WEST SUSSEX COUNTY COUNCIL CONSULTATION

TO:	Arun District Council FAO: Michael Eastham
FROM:	Stephen Gee Highways, WSCC
DATE:	27/11/18
LOCATION:	Land east of, Tye Lane, Walberton
SUBJECT:	WA/95/18/RES Approval of reserved matters following outline consent WA/44/17/OUT for the erection of 175 No. dwellings, car parking including garages, internal access roads, footpaths, parking & circulation areas, hard & soft landscaping, allotments, play areas/equipment & community orchard & other associated infrastructure & engineering works. This application may affect the character & appearance of the Walberton Village Conservation Area.
DATE OF SITE VISIT:	
RECOMMENDATION:	☐ Advice ☒ Objection ☐ Modification ☐ No Objection ☒ More Information ☐ Refusal
S106 CONTRIBUTION TOTAL:	£ See below for breakdown.

Do not scale from this drawing. Refer to figured dimensions only.  
Drawings are produced for planning purposes and are not a construction issue.

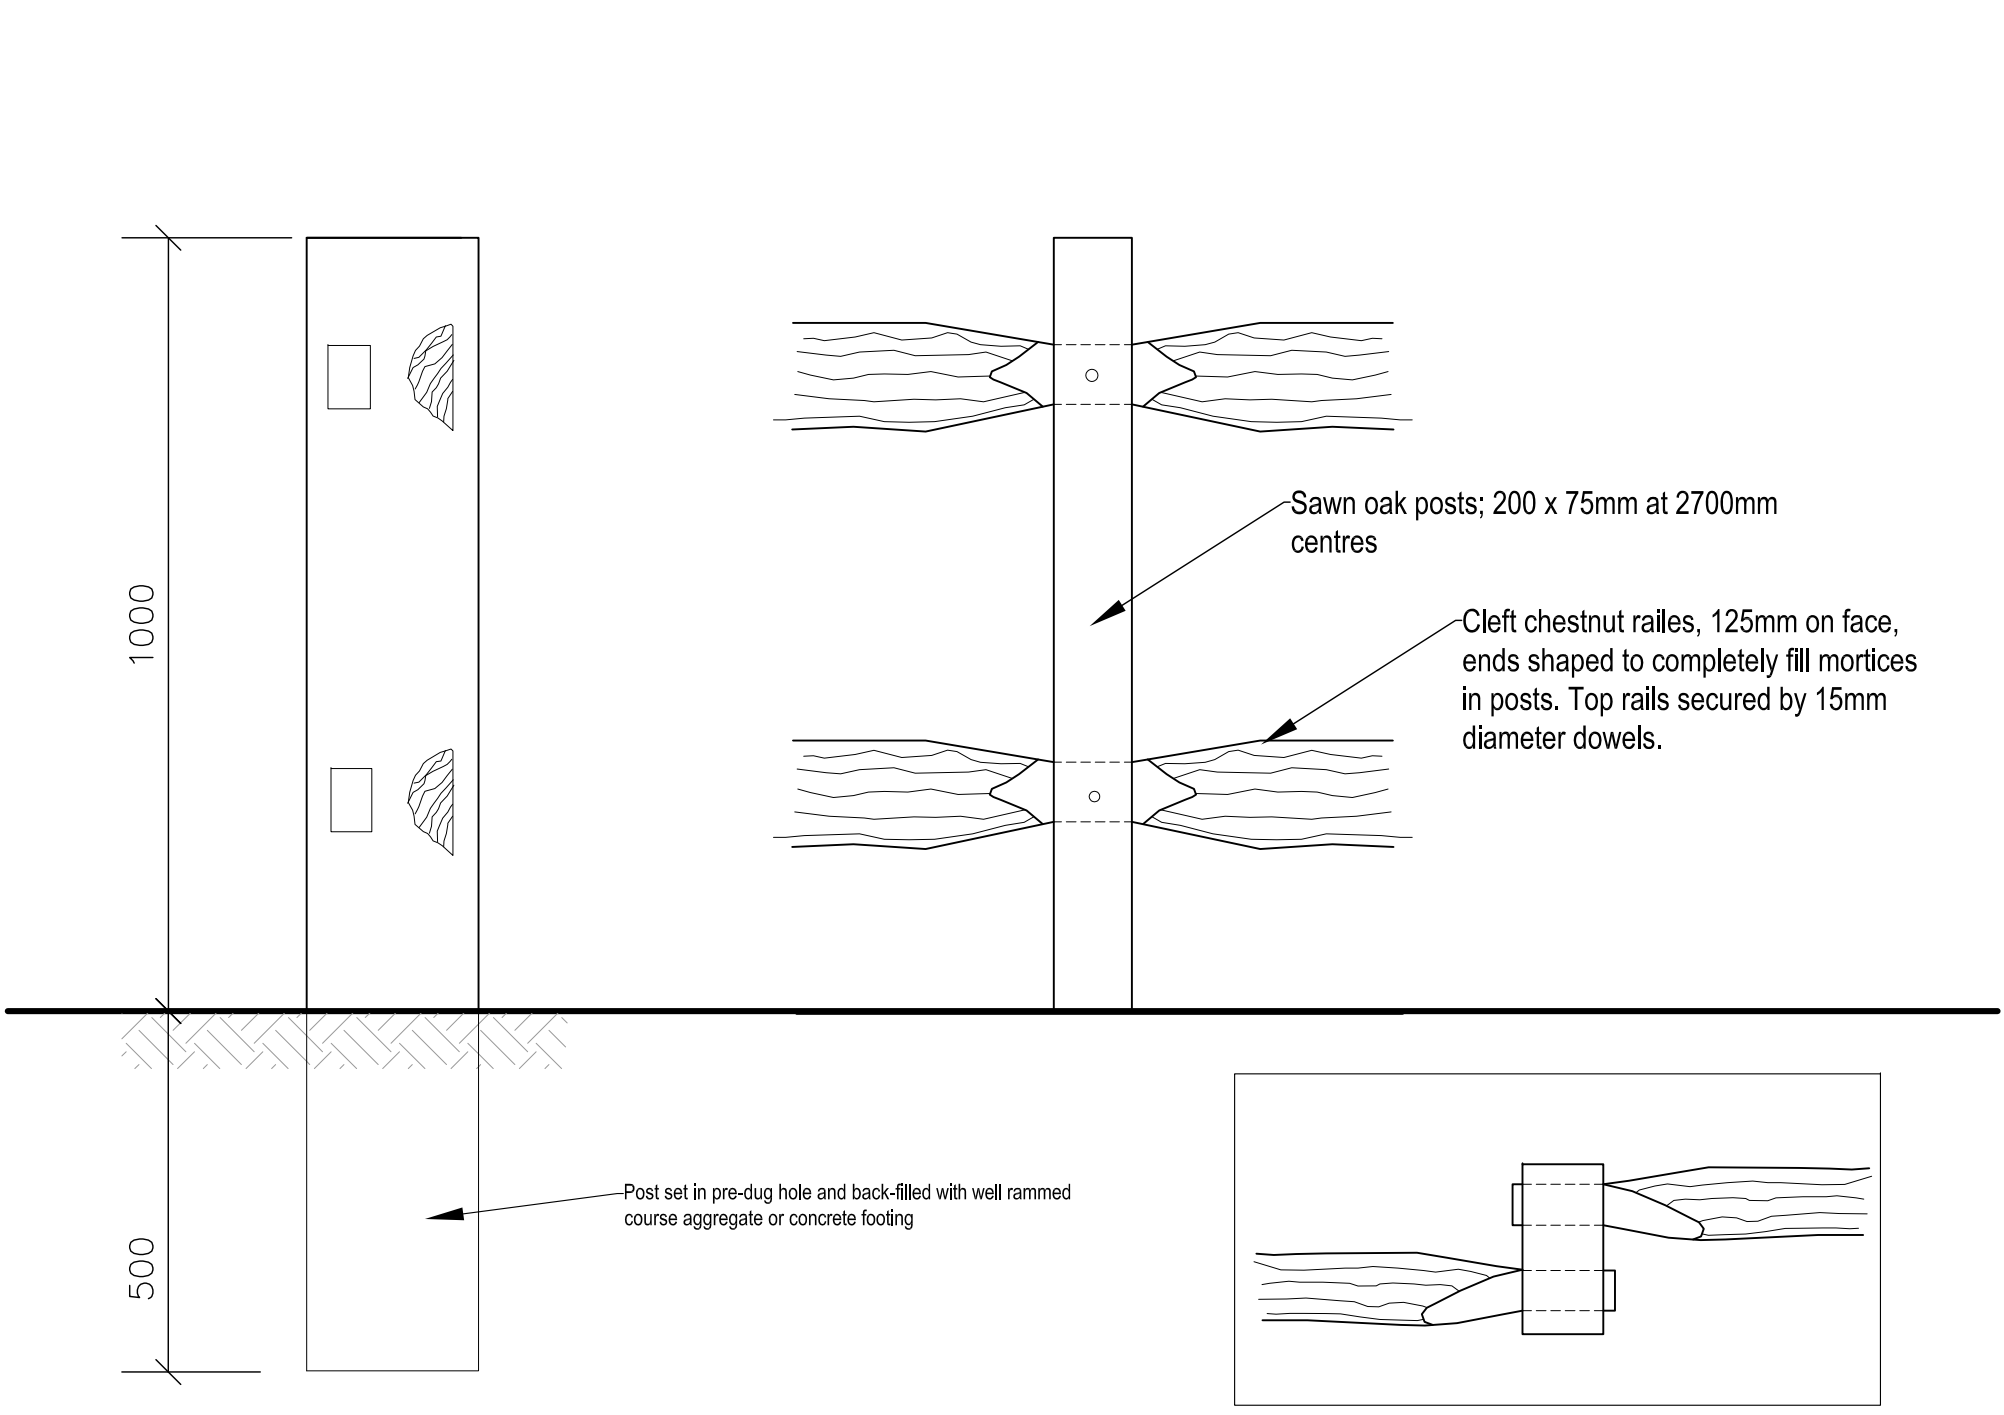
The swept path plan provided appear to show an overhang at the northern drives, when comparing this to the public open space landscape proposals it appears to show the overhang area would have timber bollards of 900mm high placed within the area.

Additional close up detail of the tracking should be provided to confirm if this is not the case, or if so the landscaping proposals amended to allow a refuse vehicle to overhang.
